Subject: Response To Application Number BE/109/19/OUT at Land east of Shripney Road & south of Haddan House
Shripney Road Bersted PO22 9NW

WEST SUSSEX COUNTY COUNCIL CONSULTATION

TO:	Arun District Council FAO: Simon Davis
FROM:	WSCC - Highways Authority
DATE:	18 February 2020
LOCATION:	Land east of Shripney Road & south of <u>Haddan House</u> , Shripney Road, <u>Bersted</u> , <u>PO22 9NW</u>
SUBJECT:	BE/109/19/OUT Outline application with some matters reserved for up to 46 No dwellings together with access. This application is a Departure from the Development Plan. More information received.
RECOMMENDATION:	More Information

Figure 3.2 – Proposed site access arrangements

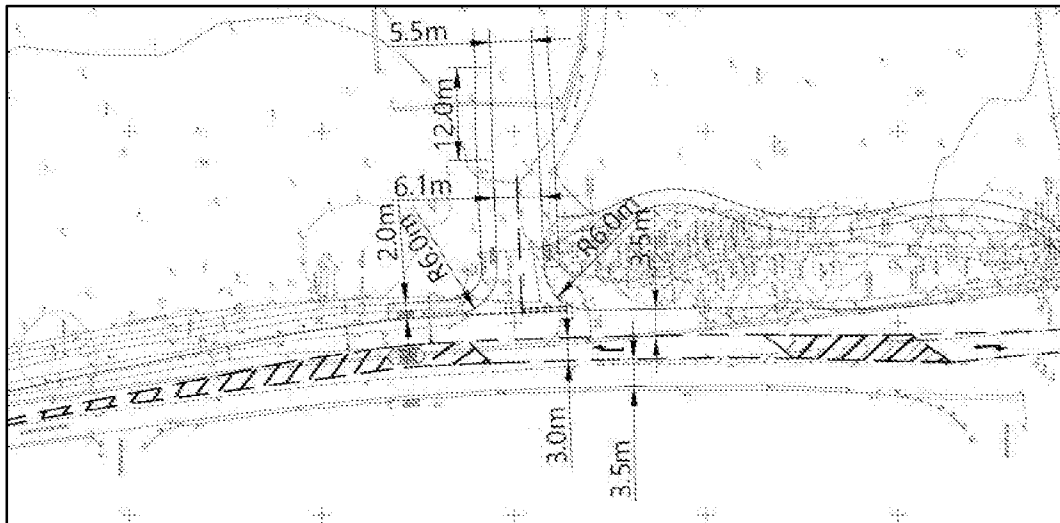
As per previous comments, the ghost right hand turn lane will provide opportunity for traffic to filter off the main carriageway before entering the site. A new bellmouth access with kerbed radii is proposed to access the development site. The kerb radii have been increased to 10 metres on northern side and 12 metres on southern side. Swept path tracking plans have been provided and demonstrate that a refuse collection vehicle can enter and exit the site without crossing opposing carriageway. It has also been demonstrated that such a vehicle can enter and exit the existing Shripney Lane junction without impacting on the new proposed pedestrian refuge island.

The new pedestrian crossing to the north of the site access has been omitted and a new splitter island proposed within the new central hatching. The new pedestrian crossing shown across the dual carriageway has been relocated to the north, with a new central pedestrian refuge island within hatching prior to existing Shripney Lane ghost right hand turn lane. An extension off the new internal private footway leads westward toward this new dropped kerb tactile paving crossing point. As per previous arrangements, the internal private footway will also lead southwards within the site to link with existing footway on eastern side of Shripney Road.

1. It is the responsibility of designers to ensure that all departures from standard are identified and reported to WSCC for consideration.
2. The design audit report does not demonstrate that all elements of the design comply with relevant standards. For example, the ghost island has not been included in the design audit report. Junction visibility from a point 15m on the minor road is also not demonstrated to be achievable. The examples are not exhaustible and it should be ensured that each element of the proposed design is set against the relevant standard that it meets (including clause number, not just DMRB chapter). The LHA would also expect that the length of right hand turn lane is demonstrated to meet standards including that hatching is correctly positioned. Currently the indicative right hand turn arrow appears to encourage drivers to turn too early.

3. The centreline of the existing road has been changed. It should be demonstrated that it still meets the curvature requirements of CD 109 table 2.10.

4. Item number 1 refers to a splay of 2.4m by 124.2m to the north – this should read south?

3. DfS 03 refers to corner radii of the new bellmouth access. Please refer to attached DfS forms for advice on how the DfS should be expanded upon and further justification given.
